SEA LINK

EN020026

Comments on Submissions received by Deadline 4

Suffolk County Council

Plate 2.1 Section of Benhall Bridge

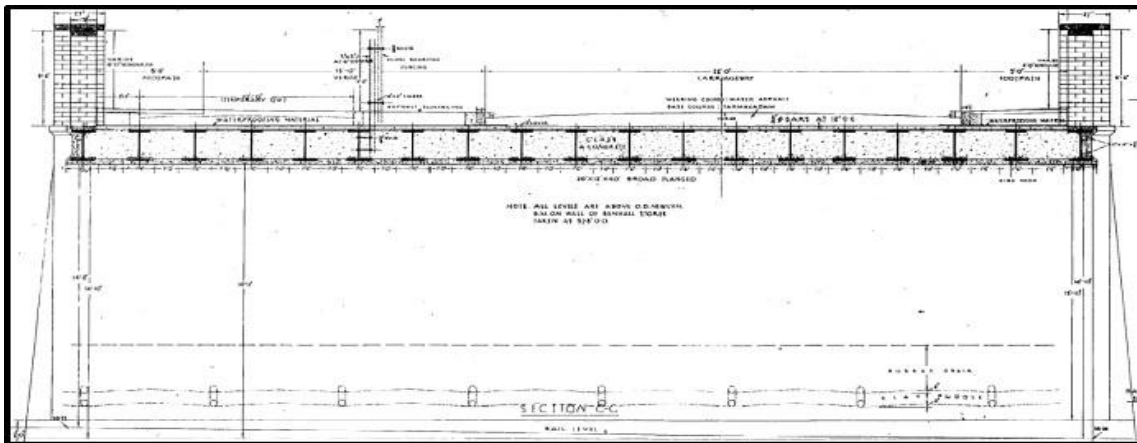
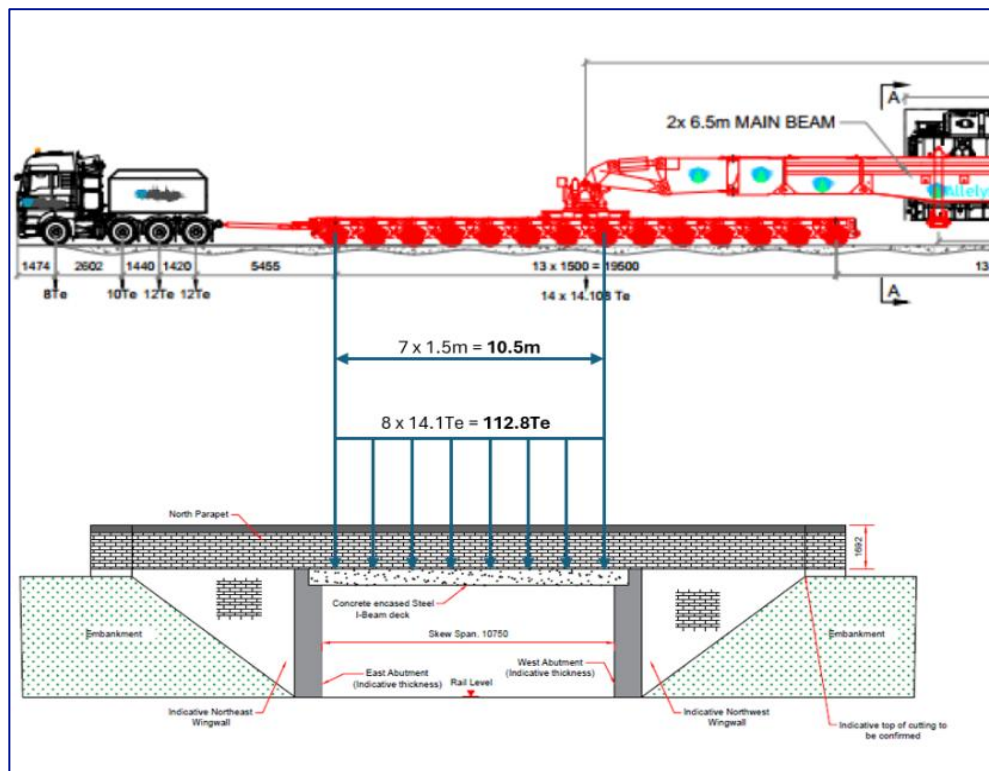
Table 12 – Document 9.112 (A) Benhall Railway Bridge [REP4-101]**SCC General Comments**

Noted that NG have replaced 100 transformers in the past 10 years but that it is not common practice for developers to assist highway authorities in developing or protecting long term resilient routes to allow access to sub stations.

The applicant has not considered any other structure on the local road network, for example those on the A12 where it is known that some structures cannot accommodate abnormal loads in terms of weight.

It is notable that restrictions on the A12 have been causing delays to AILs moving to and from the SZC project i.e. post consent. By consideration post consent this means that any impacts associated with temporary or permanent works on the highway network are not assessed in terms of impact (i.e. delay or construction impacts such as noise noting that for major routes such as the A12 this needs to be undertaken outside network peaks). SCC has encouraged all NSIP developers to undertake a feasibility study of AIL routes to their project to identify any specific concerns and generally this has been accepted (SZC, SPR, Sunnica) albeit this commonly indicates gaps in structural data requiring further review and inspection before an assessment of the structure to carry planned loads can be completed and movements approved.

SCCs position is that it is preferable to undertake repairs / improvements to the bridge to prove a long term benefit albeit an understanding of the impacts of such works would be required before making a final decision. If LionLink were to be consented with the proposal to also use this route the benefits of a long term solution are greater. To assist this SCC is working with the applicant to identify additional inspection of the structure required to design any repair or improvement works.
